Response to Submissions

State Significant Development Application – Shade Structures at the Overseas Passenger Terminal (Tenancy 5), Circular Quay West in The Rocks (SSD 9334)

Revised Plans – Sun Shade Structures and Awnings, Tenancy 5 of the Overseas Passenger Terminal

Location and View Impact Analysis

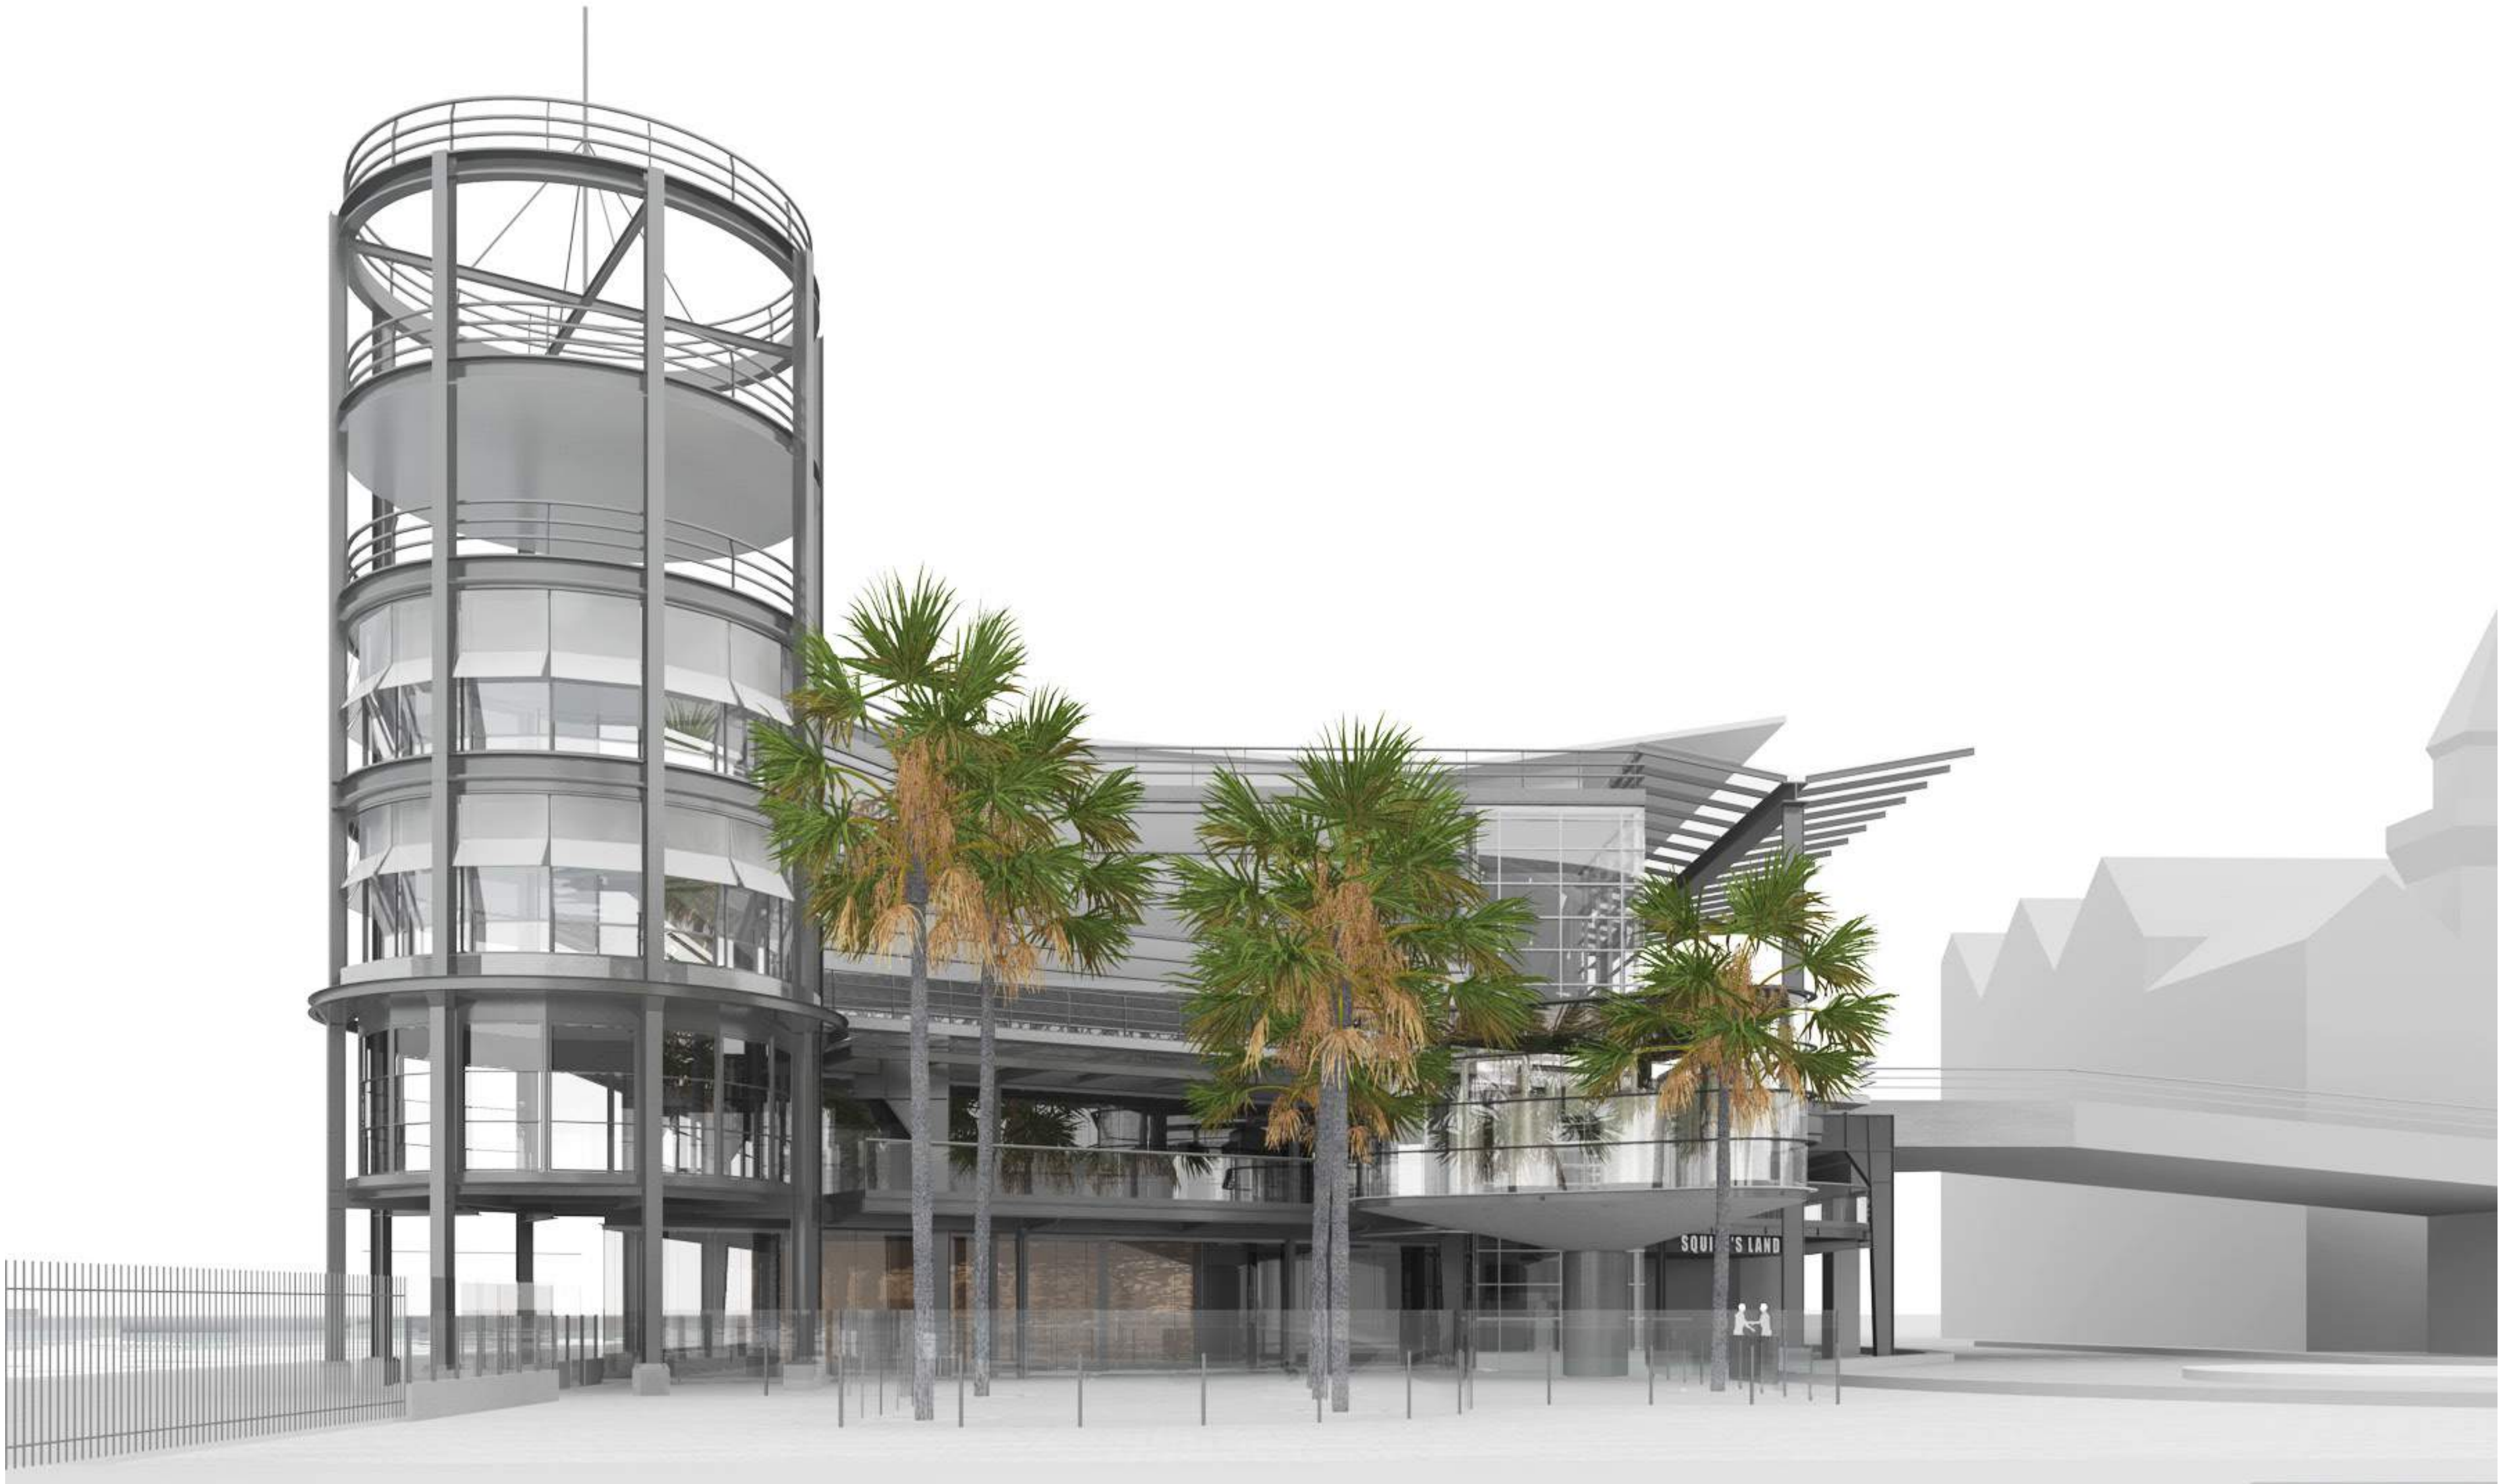
D3	<ul style="list-style-type: none"> To minimise these visual impacts to the Sydney Opera House, it is recommended that free-standing awnings are reduced in length on the northern side by one bay. To further minimise impacts, it is recommended that no pull-down blinds are connected to awnings to assist in the retention of views and vistas to the Sydney Opera House. 	<p>The HIS submitted as part of the application (Appendix D of the EIS) assessed the impact of the proposal on the SOH and in accordance with the requirements of the Conservation Management Plan for the SOH.</p> <p>The HIS determined that the proposed shade structures will be of sufficient distance from the SOH to have a minimal effect on the building's setting and context. Further, the relatively small scale of the shade structures represents a minor change to the built environment of Circular Quay and to the physical setting of the SOH which will retain its landmark qualities and continue to be perceived as a 'freestanding sculptural form'.</p> <p>Notwithstanding the above, and to address the concerns raised by OEH, the Applicant has reduced the length of the awnings for structures A1 and A2 on the northern side by one bay to further reduce any impacts on views to the SOH. Refer to the updated View Impact Analysis in the revised plan set at Appendix C.</p>

A6	vi. The views for the southern and eastern bays of TAL will be seriously impeded and obstructed;	<p>The HIS submitted as part of the application (Appendix D of the EIS) states that the proposed shade structures will not interrupt the relationship between Campbell's Stores and the harbour and are a sufficient distance from the Campbell's Stores building to have a minimal impact on the setting of the building. Further, view impacts from the Campbell's Stores toward the SOH are addressed by reducing the awning length for structures A1 and A2 as part of this RtS.</p> <p>The reduced view impacts are shown in the updated View Impact Analysis provided in the revised plan set at Appendix C.</p>

Part Elevation - A2 and A3 Overlap

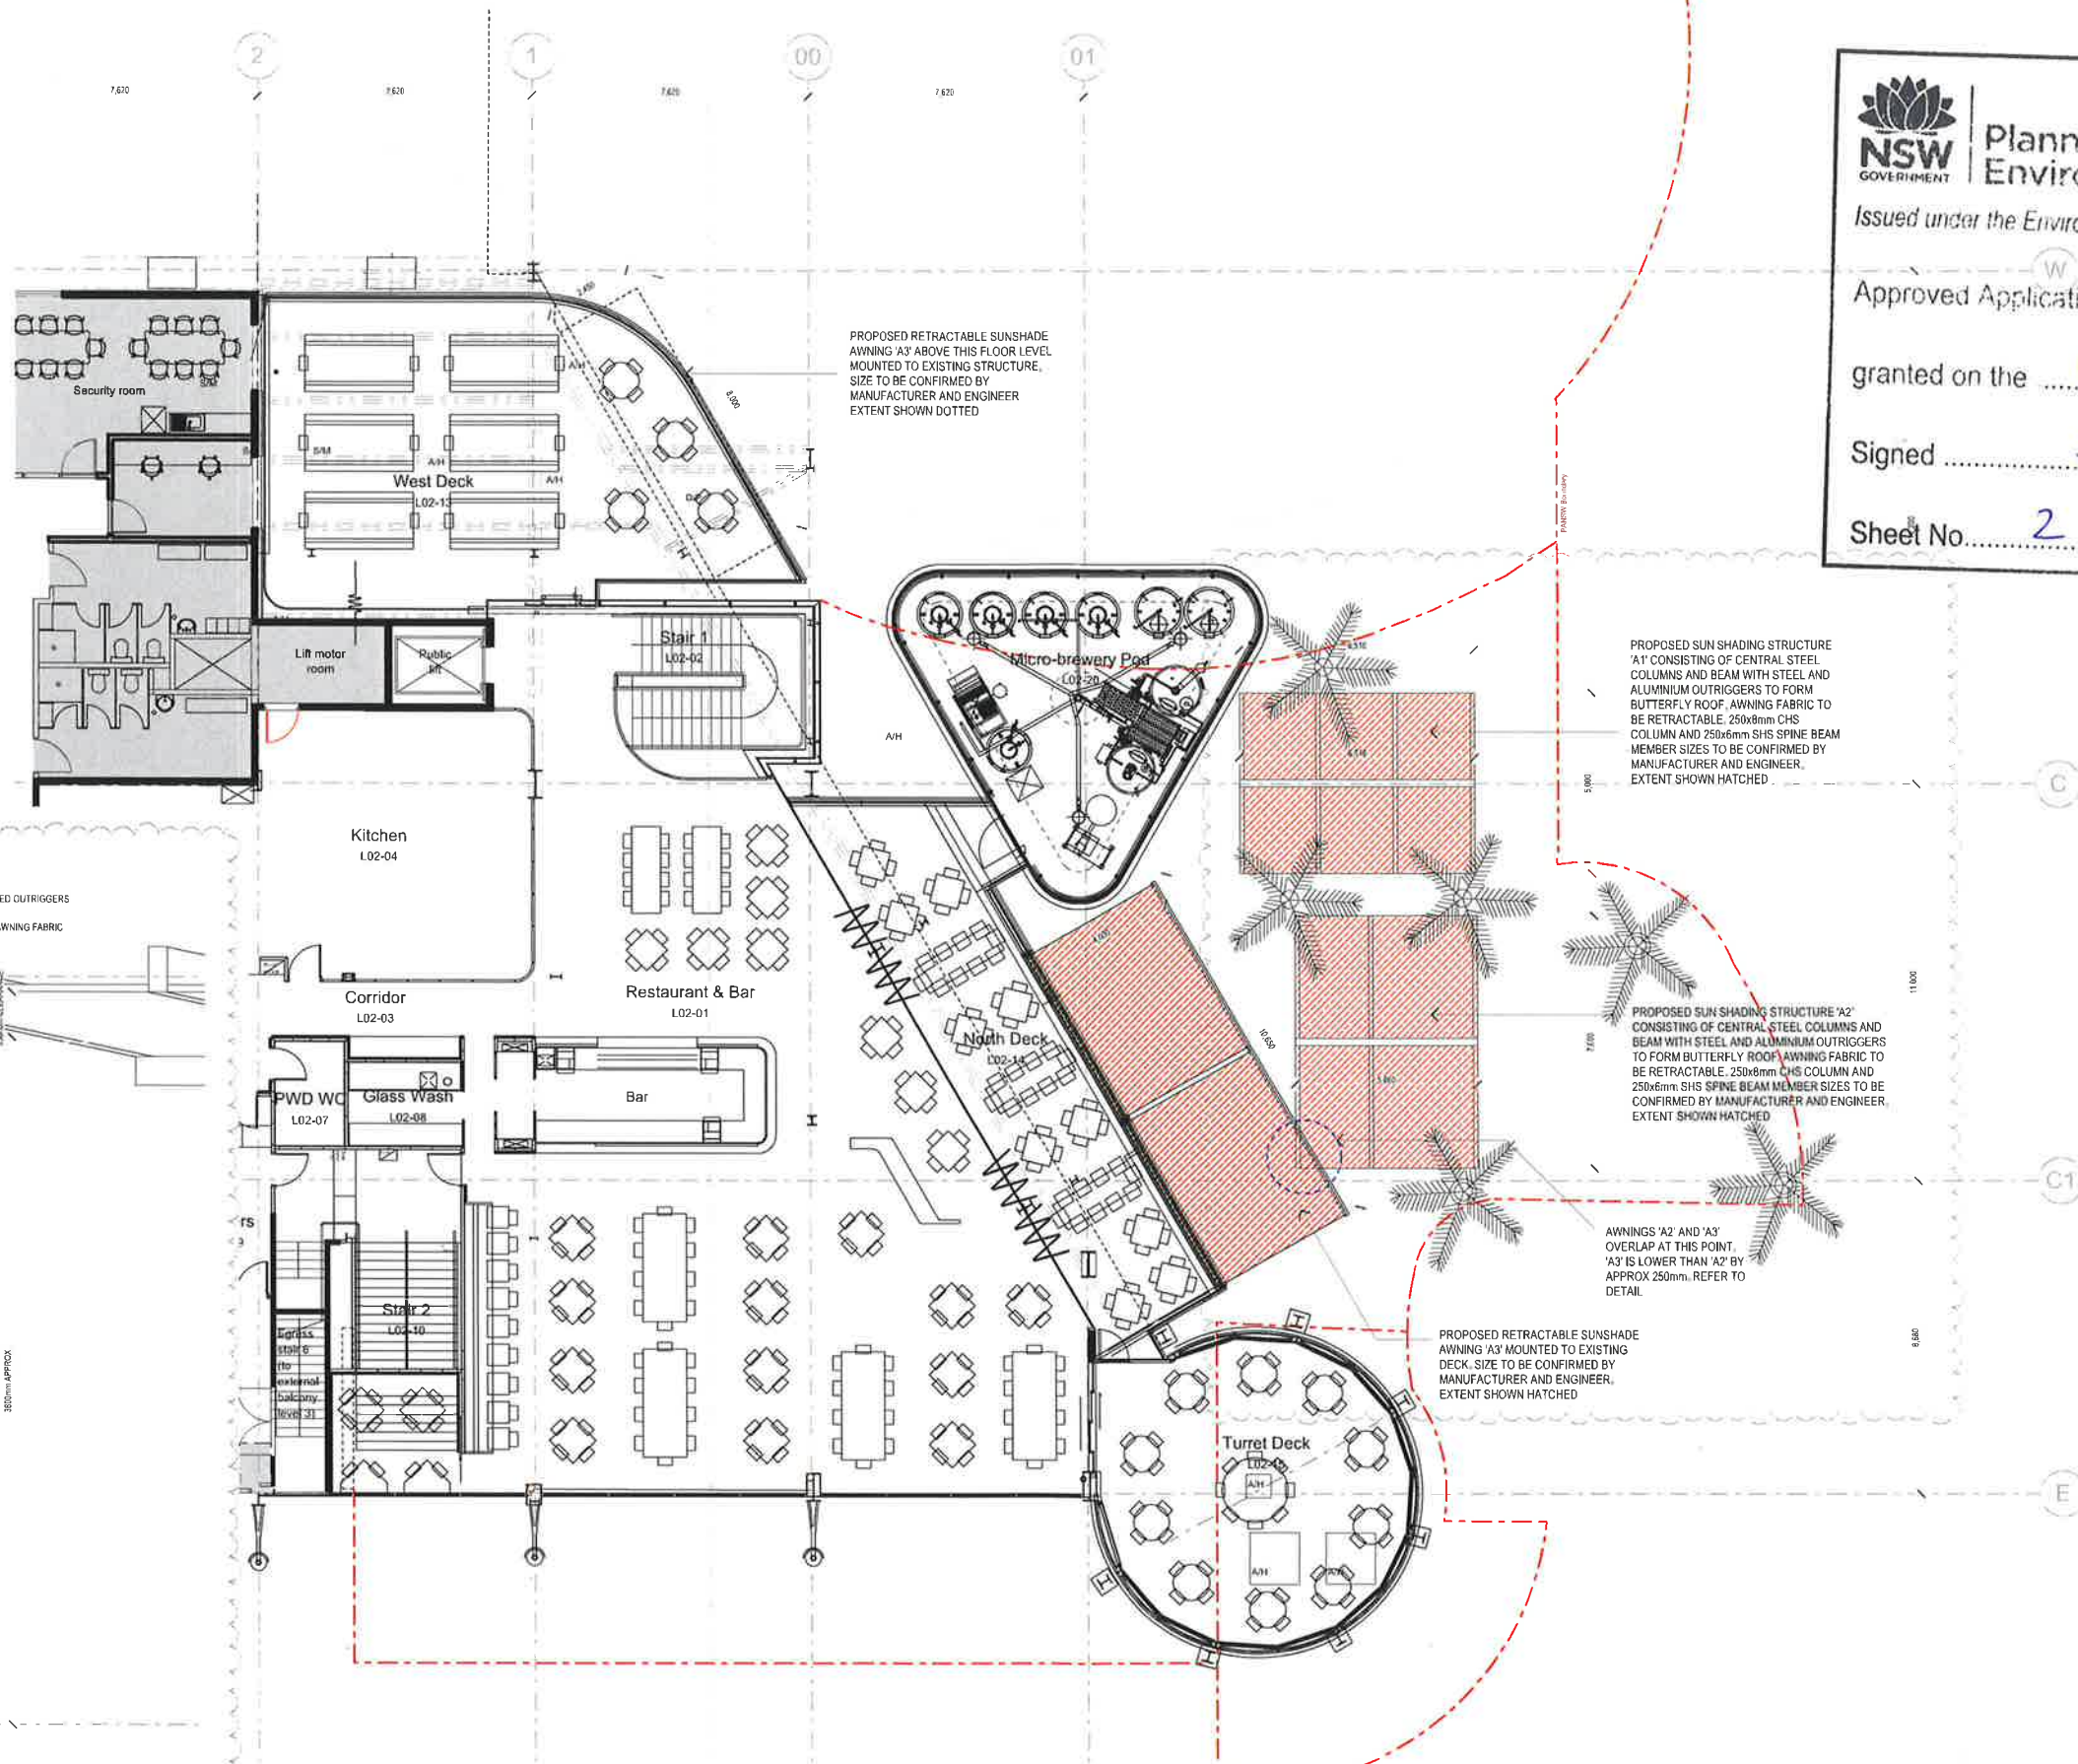
A3	<p>With respect to the two retractable free standing shade structures (A1 and A2), the City would like to draw the Department's attention to those aspects of the proposal that appear to require further resolution:</p> <ul style="list-style-type: none"> Parts of the shade structures 'A2' and 'A3' overlap, which contradicts the elevation where they appear to be at the same height. How do they integrate with each other and will this affect their operability? 	<p>There is a small overlap for shade structures A2 and A3. Proposed structure A3 (which will be mounted to the existing deck) would be positioned approximately 250mm lower than shade structure A2. There will be no impact on the operability of either structure.</p> <p>The overlap of structures A2 and A3 are shown in the revised plan set at Appendix C (refer plans TSL DD-100-SK02 C and TSL DD-100-SK12 A).</p>
A4	<ul style="list-style-type: none"> The view analysis image labelled 'View 1 – Proposed' is somewhat misleading as the proposed structures are shown to be in the shade and a grey colour. Perhaps they are shown in a retracted position which is less helpful. The application indicates that the fabric will be an off-white colour, which should be properly reflected in the view analysis material submitted. 	<p>The view analysis image is an indicative view only and is considered to provide an appropriate representation of the proposed shade structures, as viewed from the eastern side of Sydney Cove.</p> <p>Notwithstanding, a revised view analysis showing the shading fabric as an off-white colour has been prepared and is submitted as part of the RtS (refer revised plan set at Appendix C). The revised view analysis demonstrates that there will be a negligible visual impact.</p>
